EXTENT OF CAR STACKER BELOW

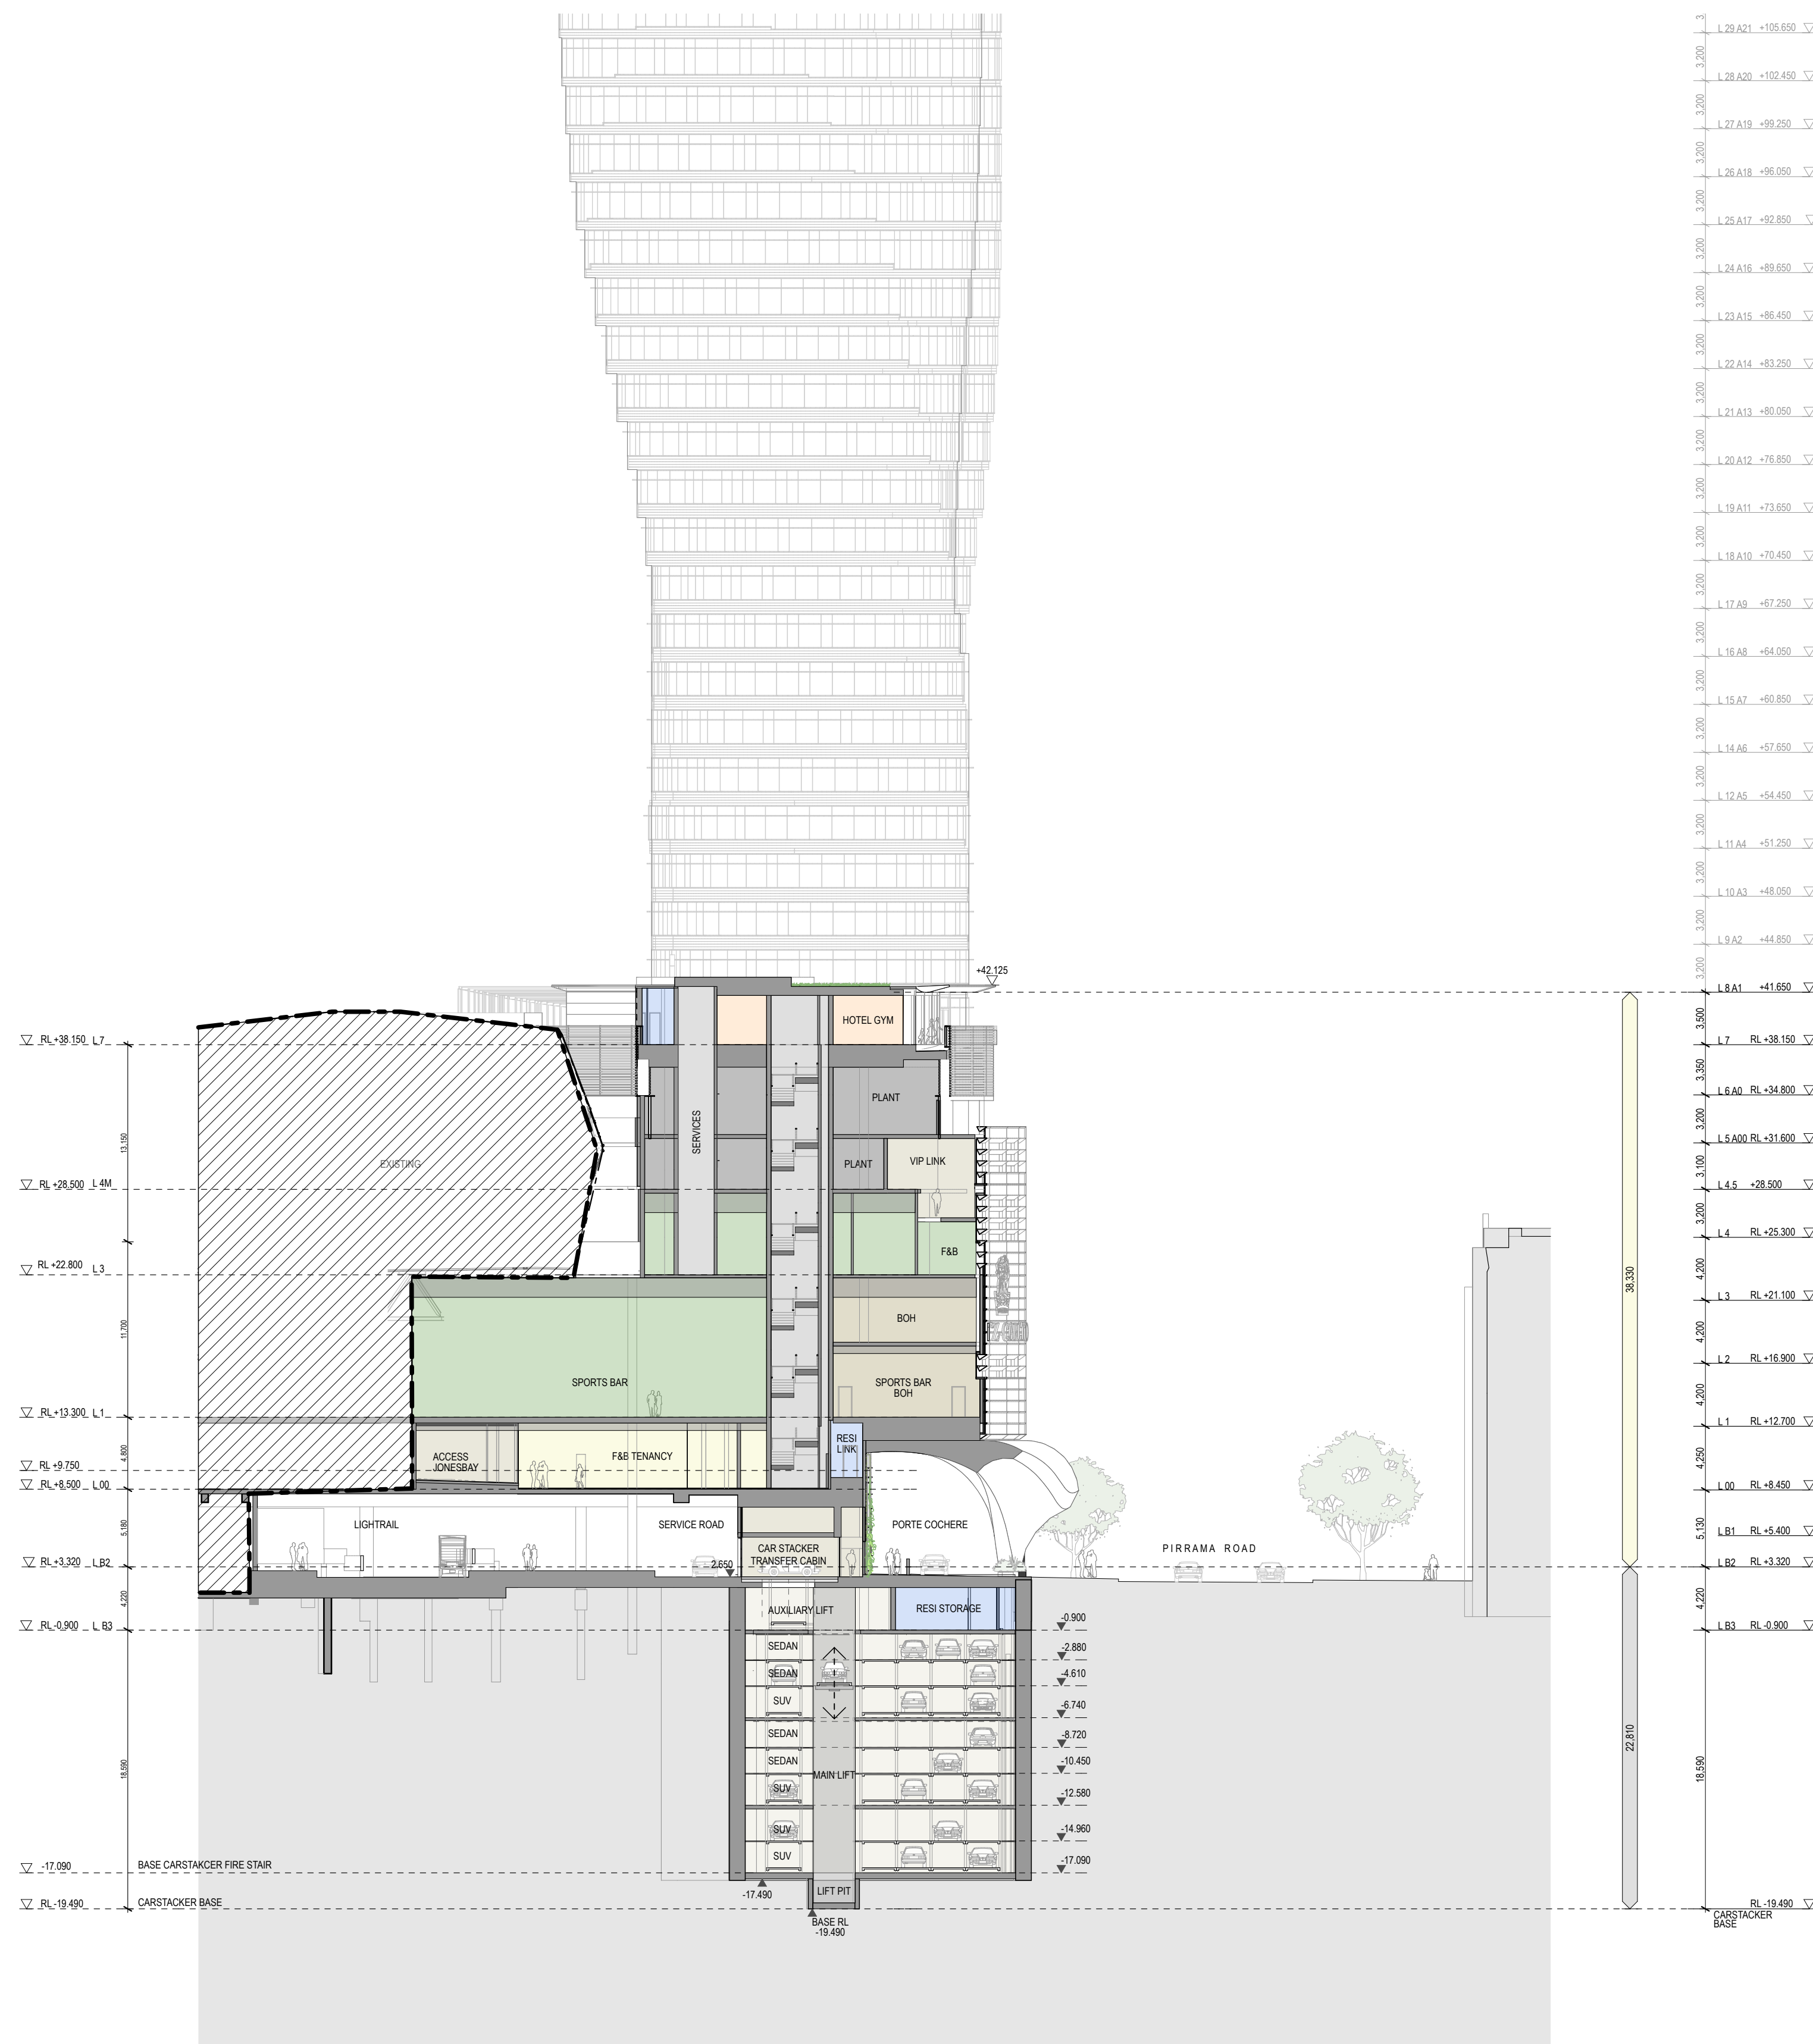
Formal Lodgment AF5102 Detail Section D02

Revised AF5102 Detail Section D02 - showing reduced car stacker extent
